Letter from DPI dated 2/7/13

Subject: Submissions received on proposed Concept Plan for a mixed use subdivision at Culburra West – part lot 5, part lot 6 and part lot 7 in DP 1065111 and lot 61 in DP 755971, Culburra Beach (09_0088)

Concept Plan for Mixed Use Subdivision at Culburra West – MP09_0088

Subject: Mixed Use Subdivision Concept Plan at West Culburra – MP 09_0088

Figure 11

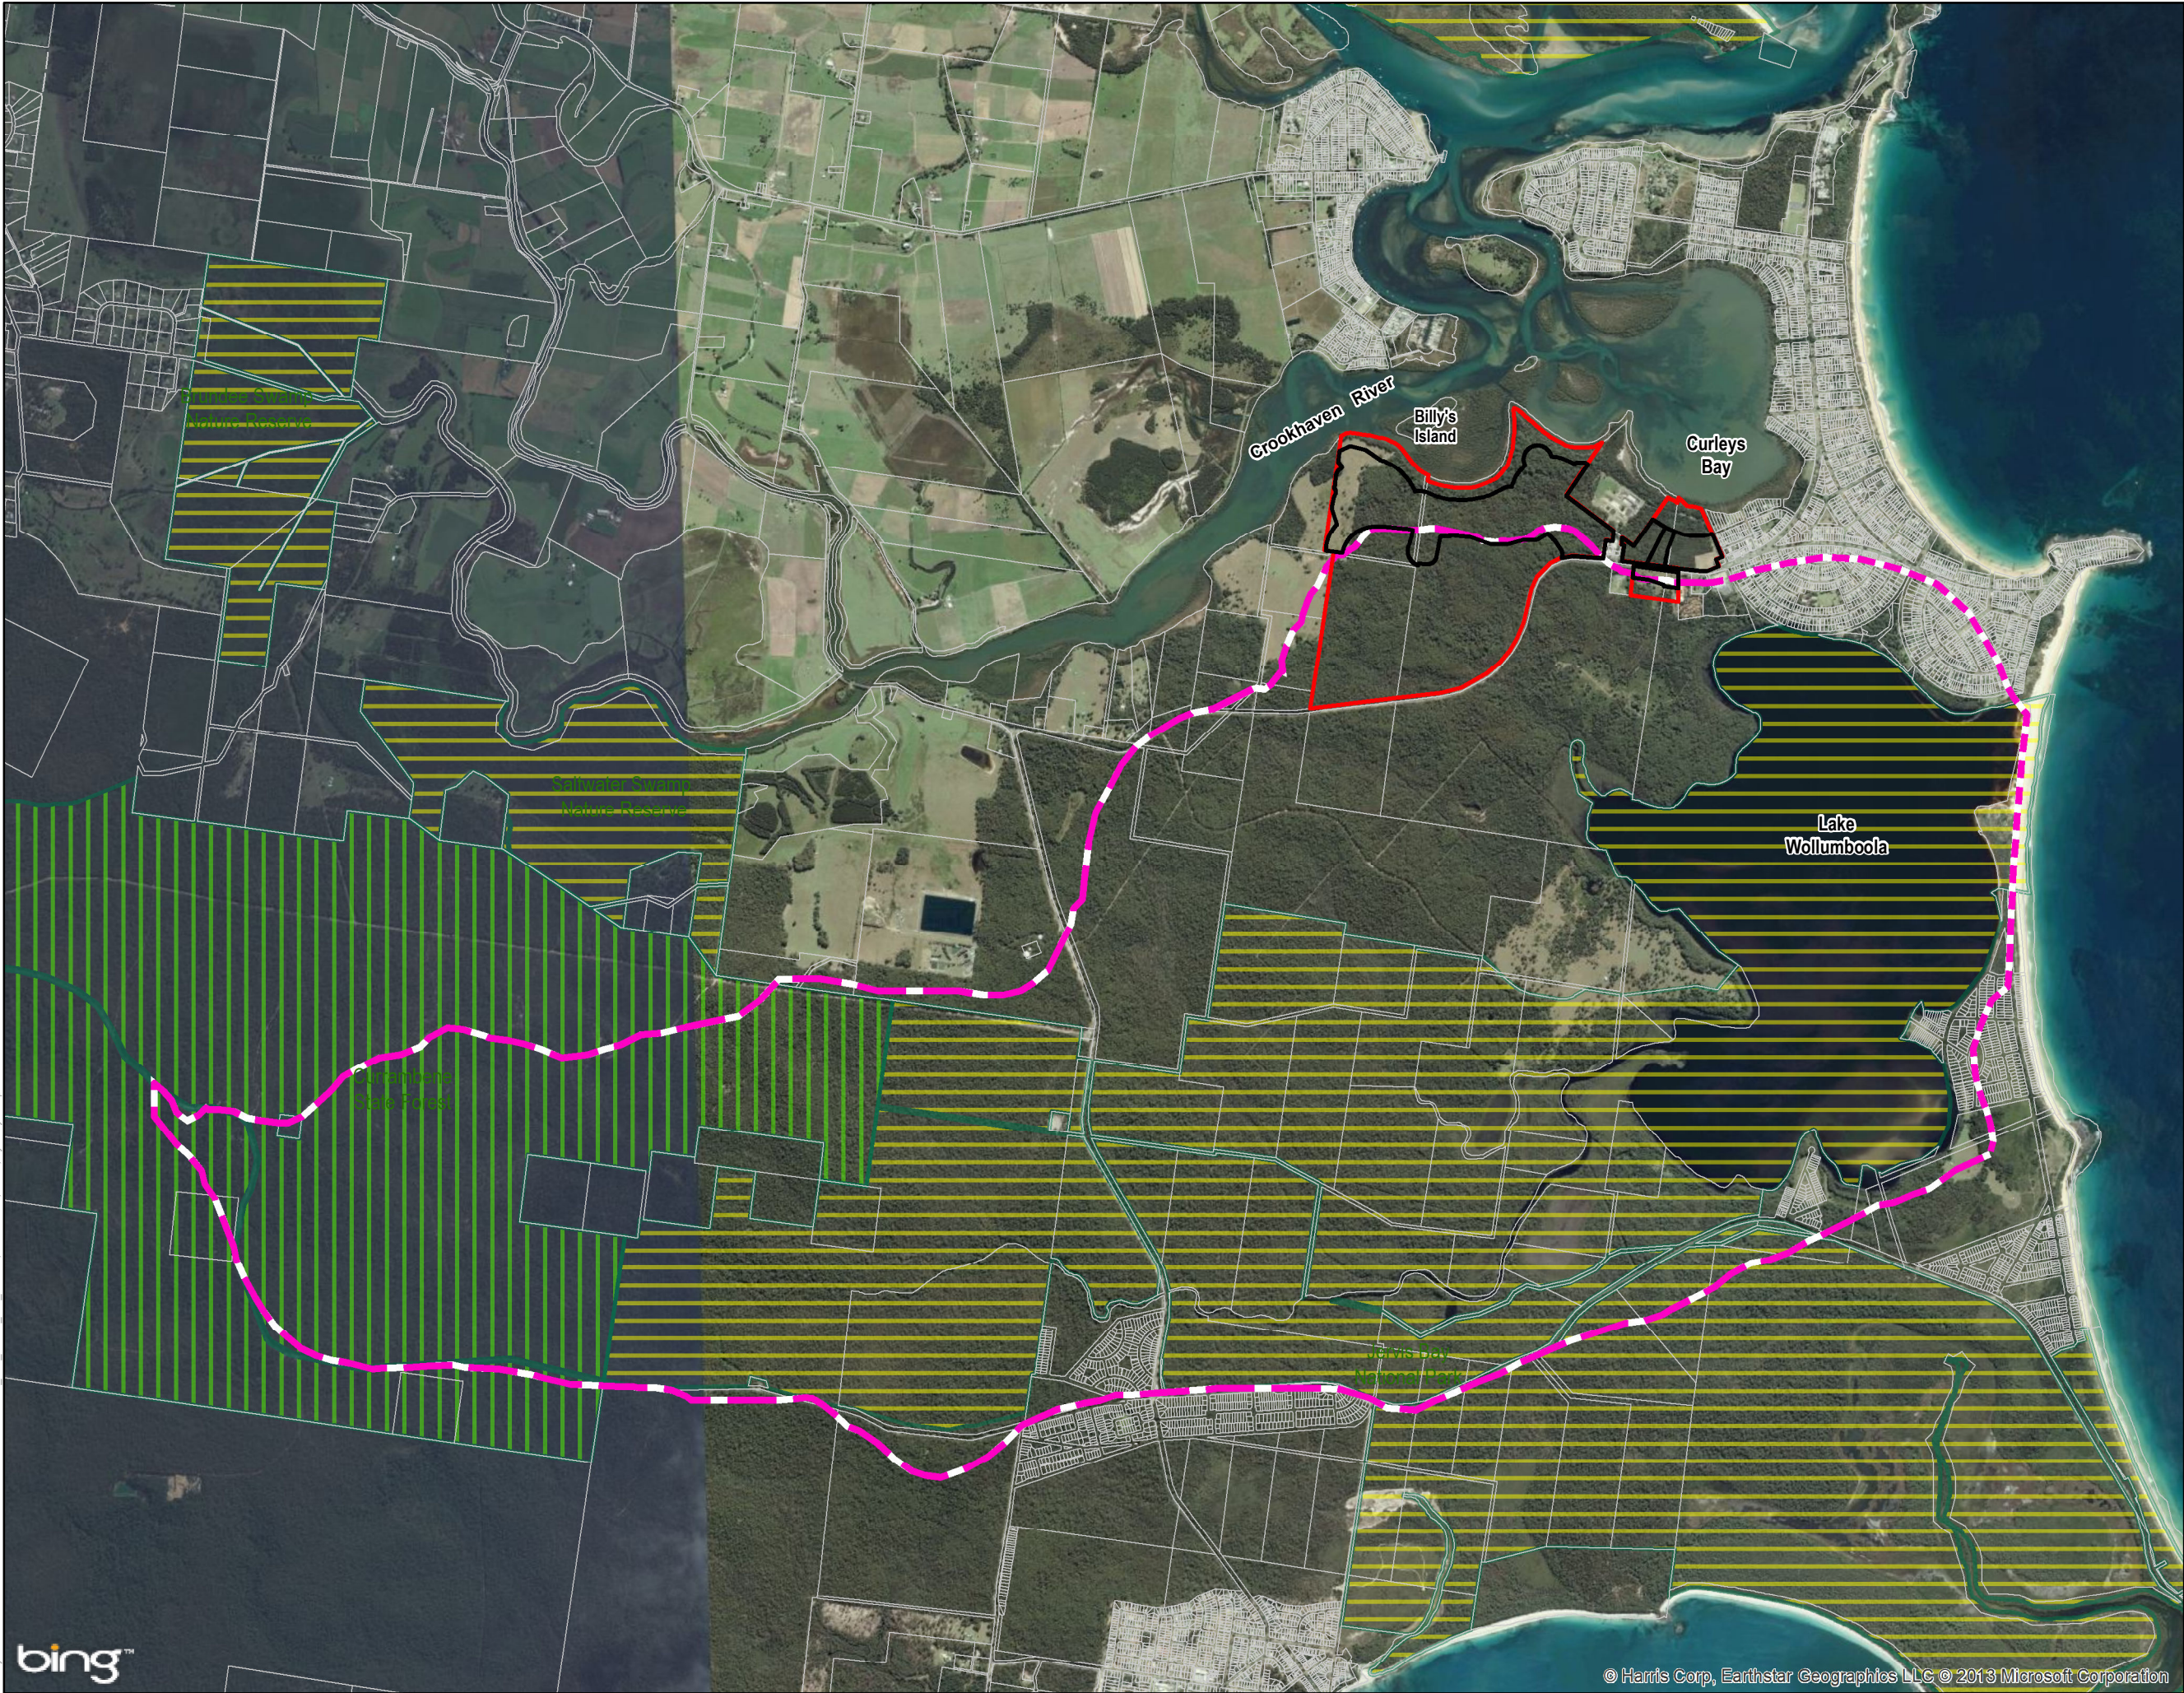
The application does not provide enough justification for the following elements to be allowed within the within the Lake Wollumboola Catchment:

- parts of the collector road and corresponding parts of the some residential lots;
- the roundabout;
- the oval;
- part of the road reserve within the 3.4ha medium density site;
- the southern part of Stage 1; and
- the south western part of the Stage 5 industrial estate.

It is acknowledged some development is unavoidable in the catchment, eg the roundabout but it is still important to justify all breaches and address any adverse environmental impacts and mitigation measures.

2.1 Parts of collector road and some residential lots.	Parts of the collector road. Collector Road retained; residential lots deleted adjacent to industrial zone.	See Section 9.1 and Concept Plan.

2.2 The roundabout.	The roundabout. Retained in its location. Swale added to Wattle Creek.	See Section 9.2, Figure 12 and Addendum to Water Cycle Management Plan (Appendix 7).

2.3 The oval.	The oval is located on the most suitable site. Oval and associated access and pondage retained. Location endorsed by Council.	See Section 9.3, Concept Plan and Addendum to Water Cycle Management Plan (Appendix 7).

2.4 Part of the road reserve in the 3.4ha medium density site.	Collector road alignment adjacent to the oval retained.	See Section 9.4 and Concept Plan.

2.5 The southern part of Stage 1.	Southern part of Stage 1 retained. Detailed site survey enabled area that can be drained by gravity to Culburra Road to be proved up.	See Section 9.5, Concept Plan and Figure 15 for preliminary layout of Stage 1.

2.6 The south-western part of Stage 5.	South-western part of Stage 5 (the industrial zone) is retained.	See Section 9.6, Concept Plan and Addendum to Water Cycle Management Plan (Appendix 7).

ROUNDAABOUT 01 VEHICLE MOVEMENT LAYOUT PLAN
SHEET 01
OVER CULBURRA ROAD
AT CULBURRA BEACH
FOR SEALARK PTY LTD

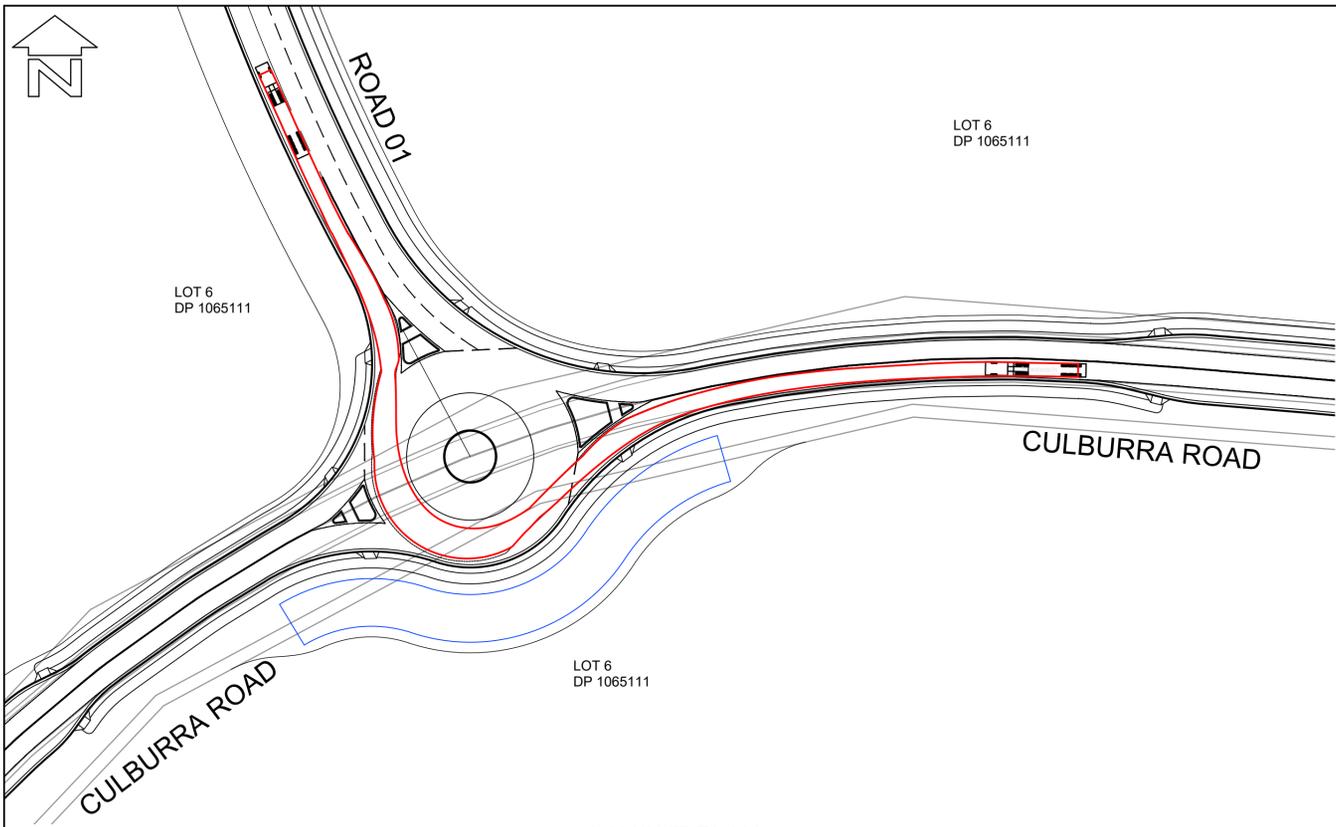
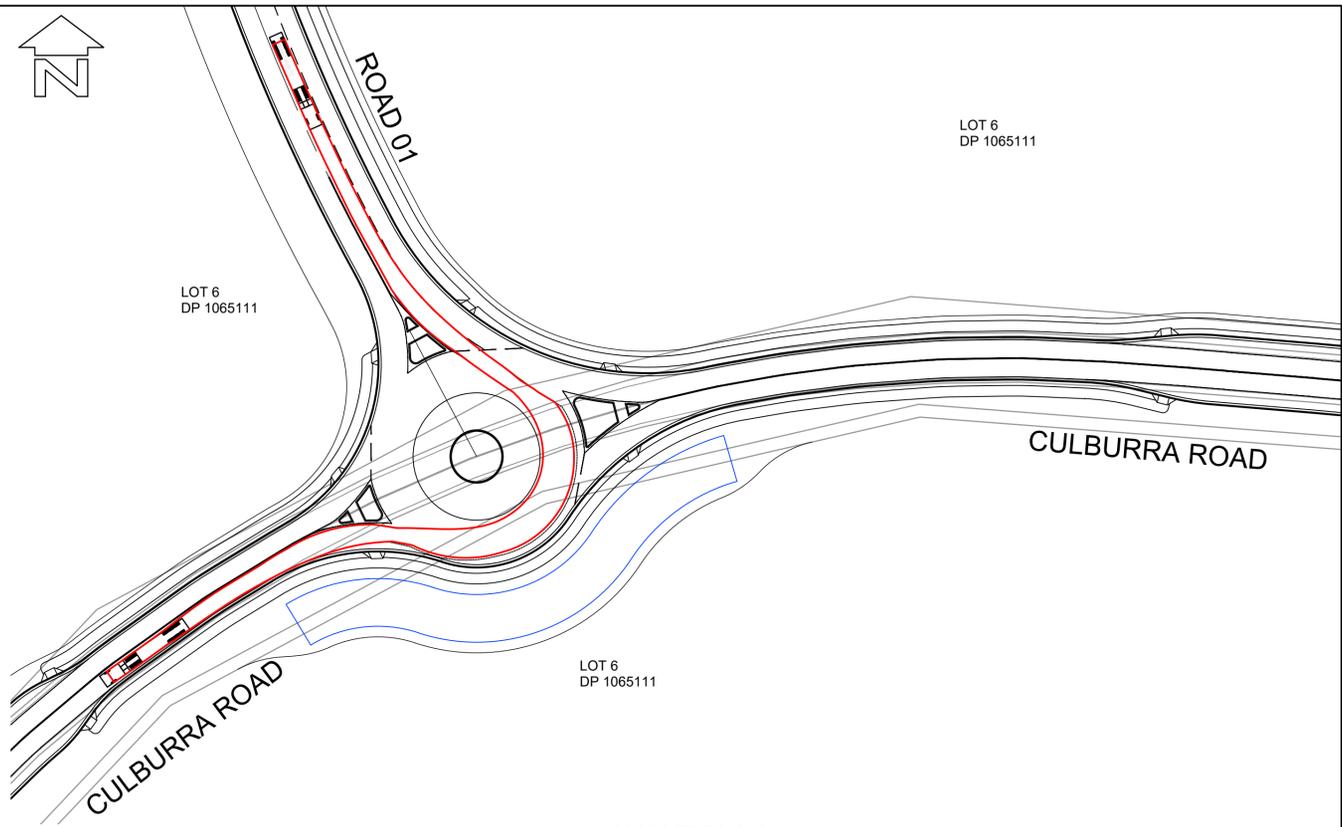
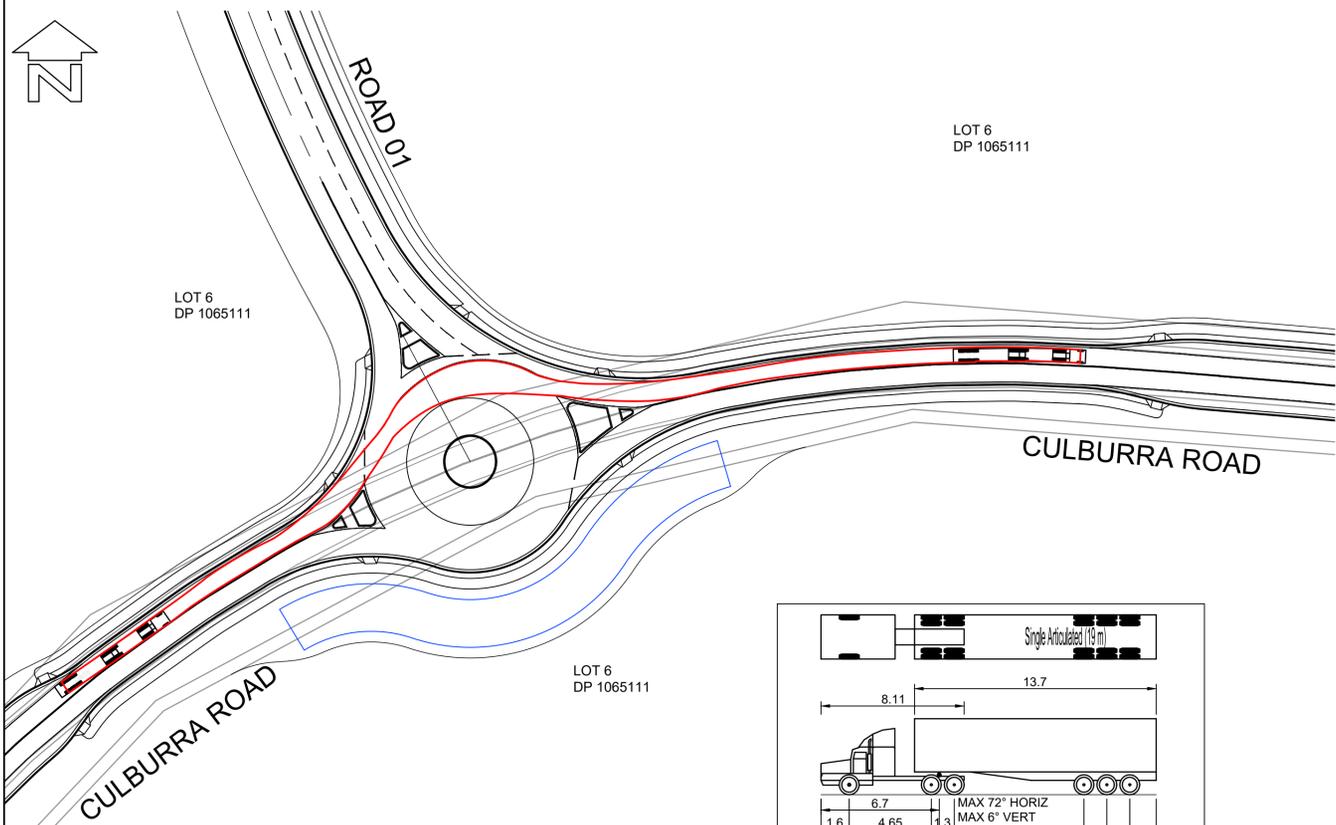
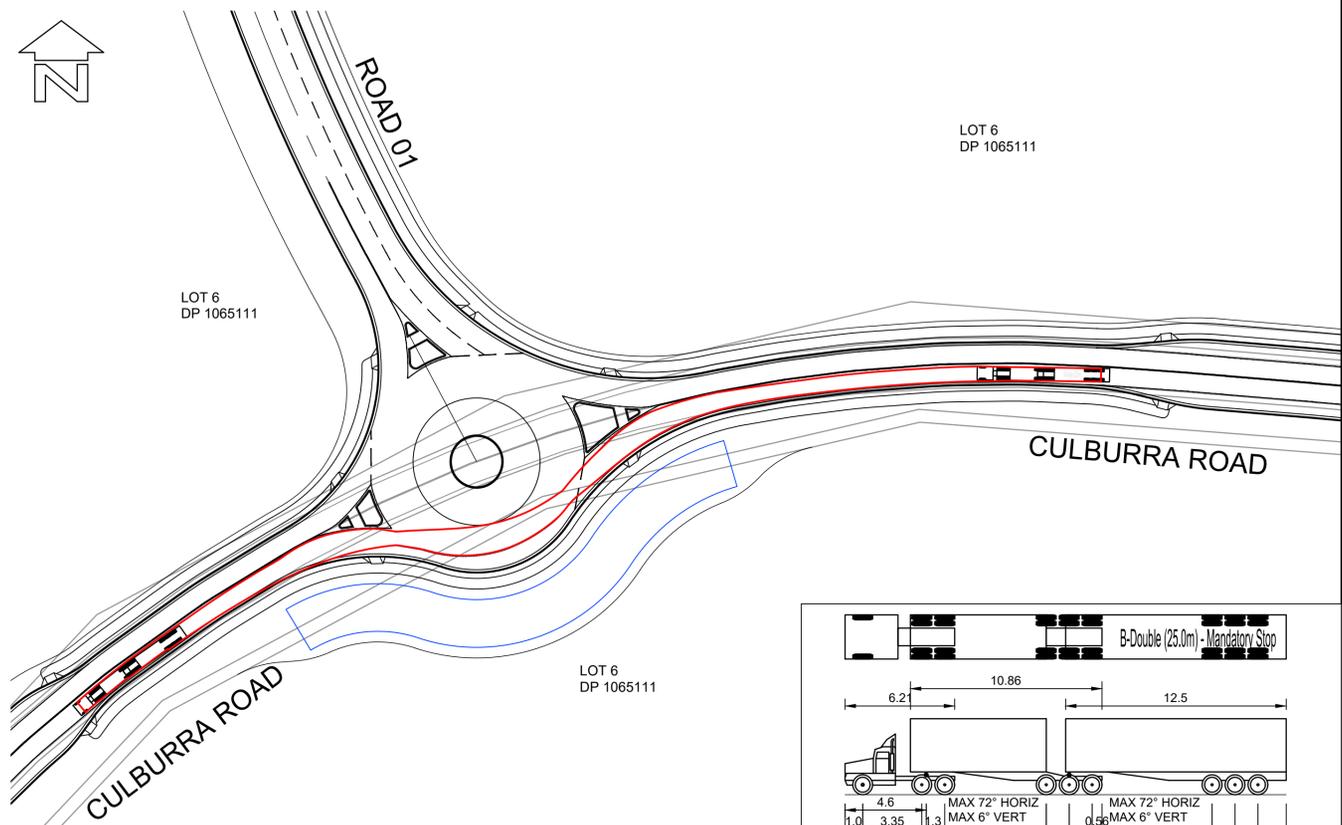
The RMS and council do not support the separate access to the stage 5 industrial area off Culburra Road, for safety reasons. All access to the stage 5 industrial area should be off the proposed roundabout and new collector road.
